Final Report - Corrections Required **Application No. ANEX-24-0004**

Description : Matrix Design Group on behalf of Colorado Springs Equities LLC is submitting a serial annexation petition for seven parcels and Land Use Plan/Rezoning exhibit for a portion of the subdivision known as Rock Creek Mesa.

Document Filename : 224.023-LEGAL-RCM ANNEX 4.pdf

# ANNEXATION PLAT ROCK CREEK MESA ADDITION NO. 4

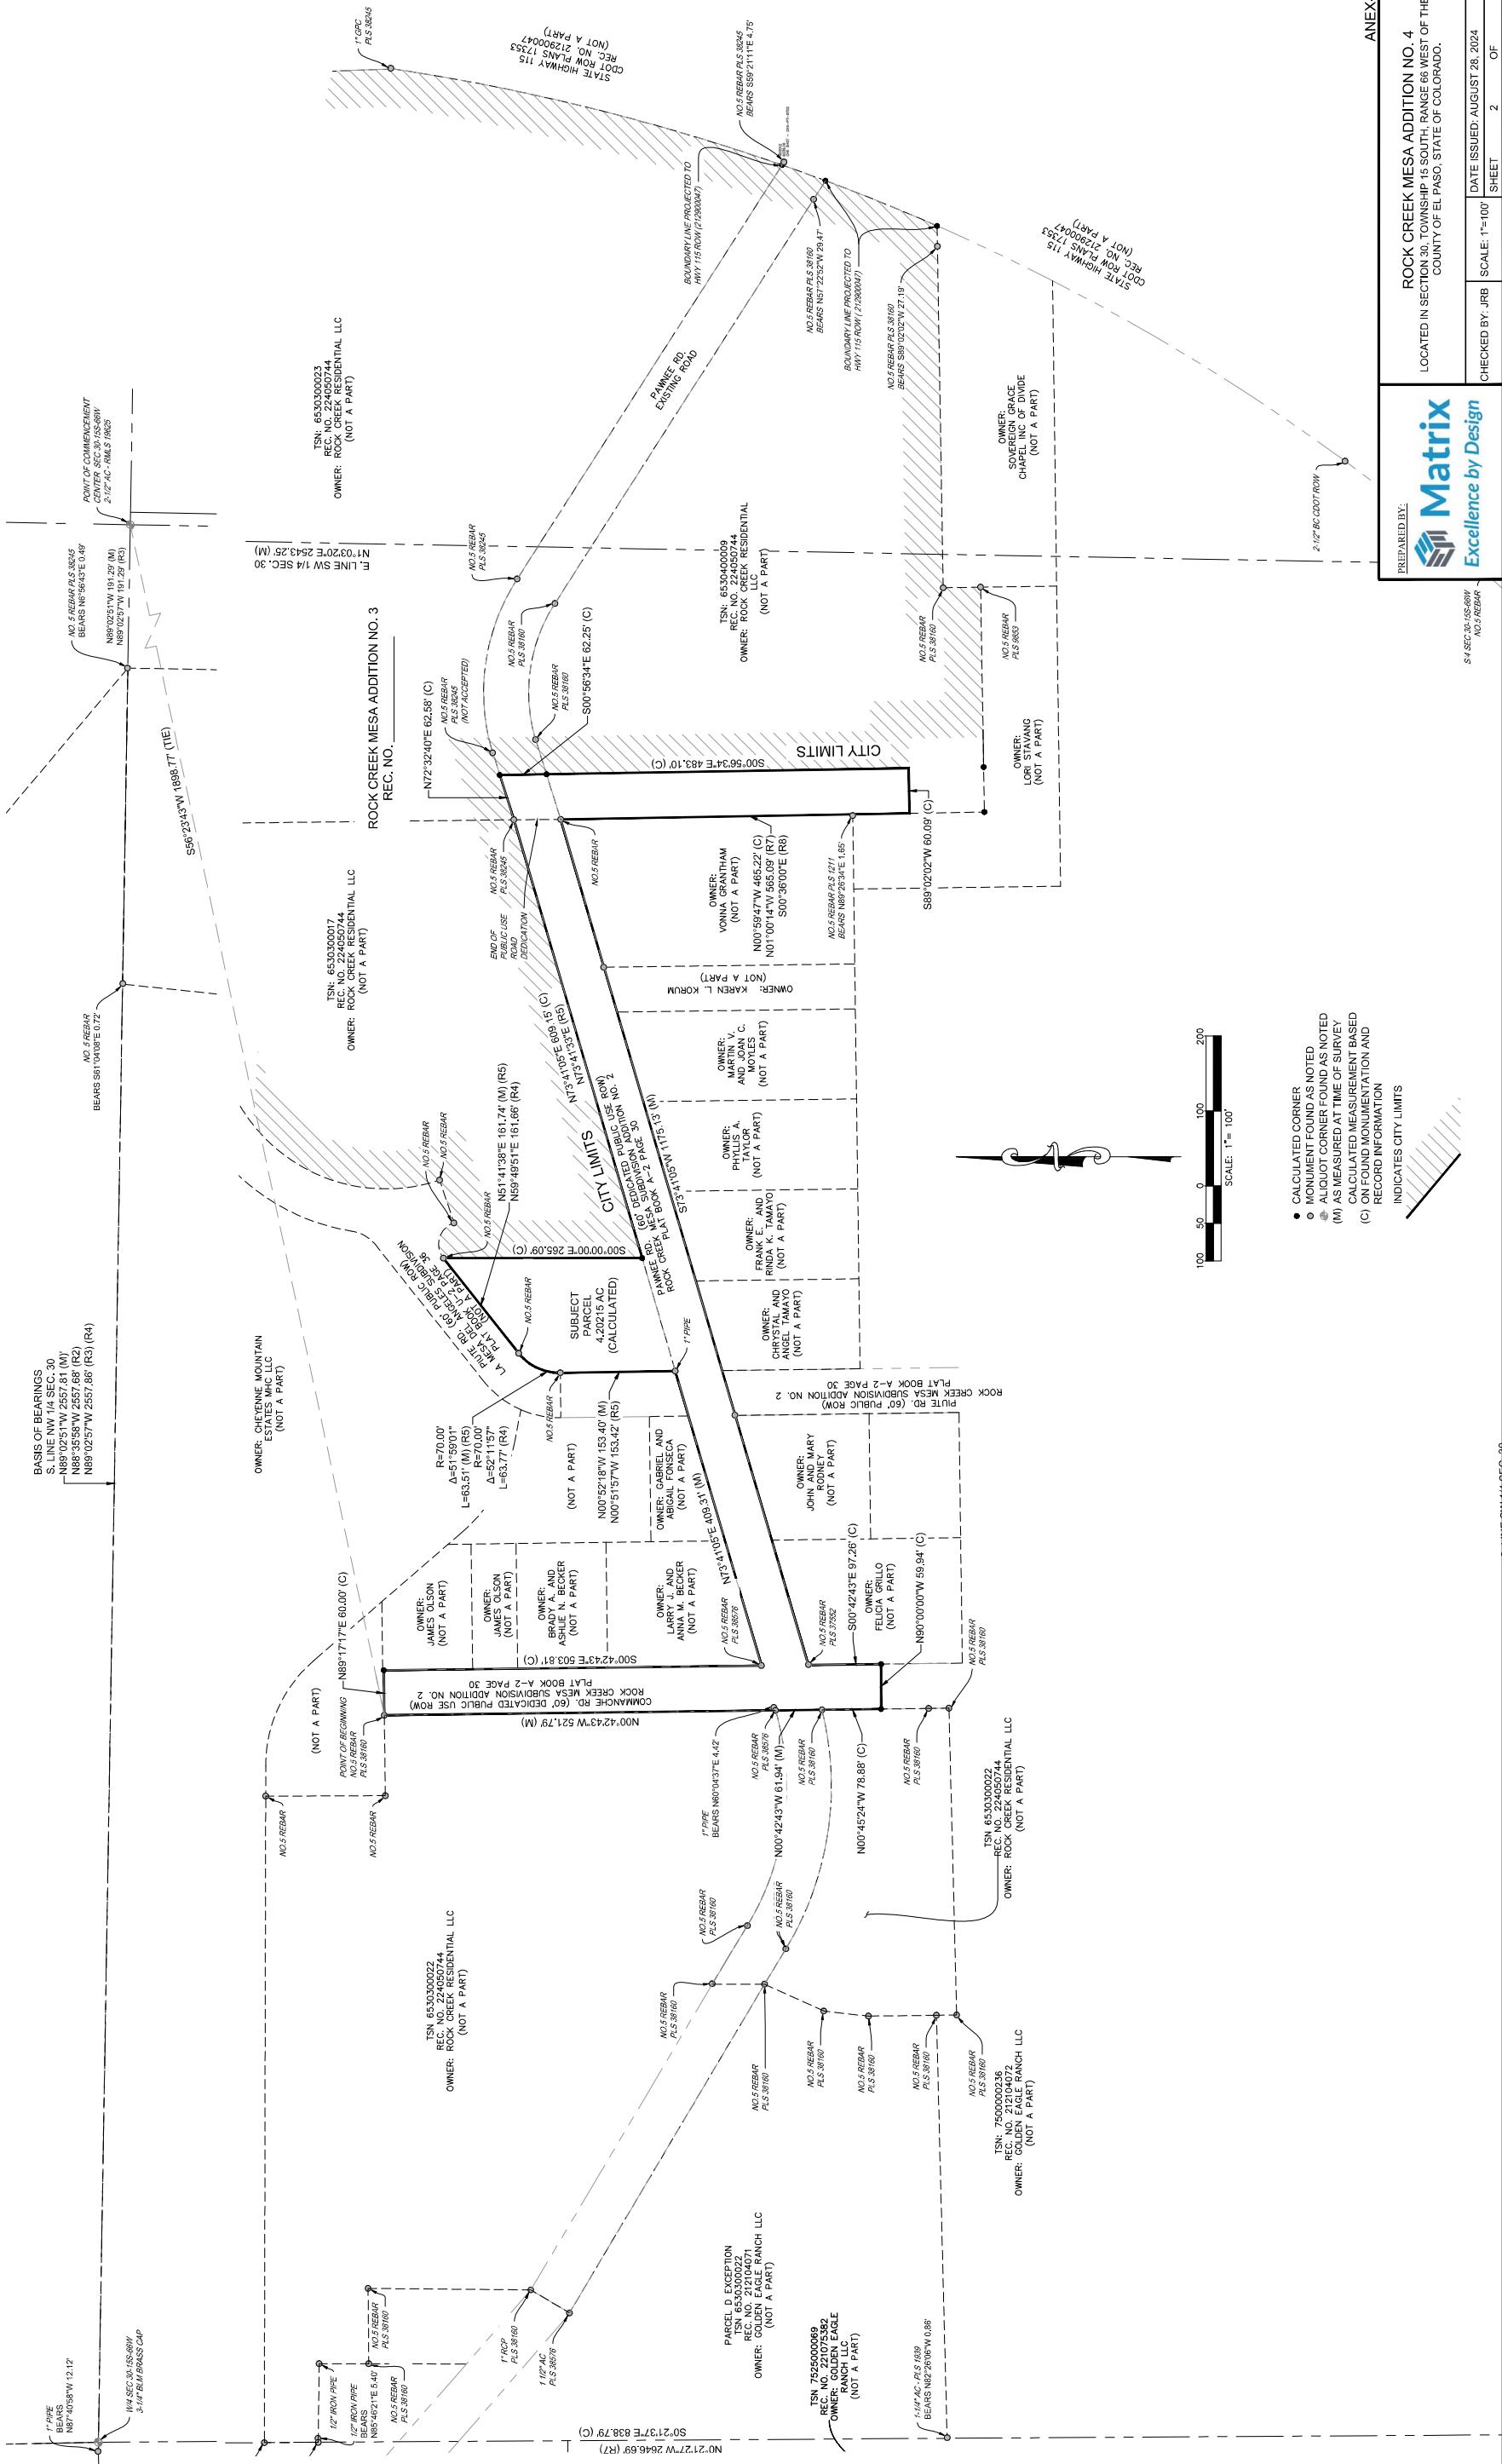
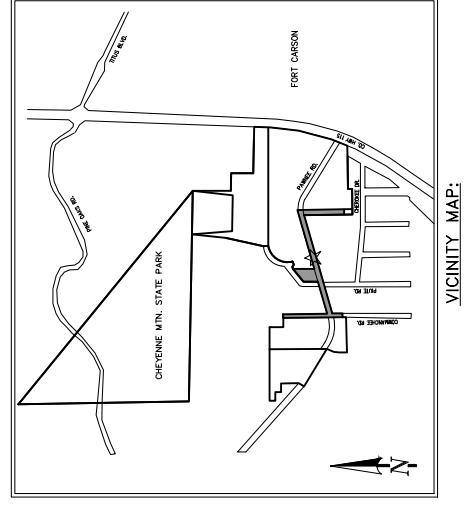
Please revise exhibit A to:
Rock Creek Mesa Addition No. 4

Please check/revise the bearing S72-19-47W closure

Shouldn't there be calls to and along HWY 115?

Add file number
ANEX-24-0004 to both

Please add the area at the end of the legal description
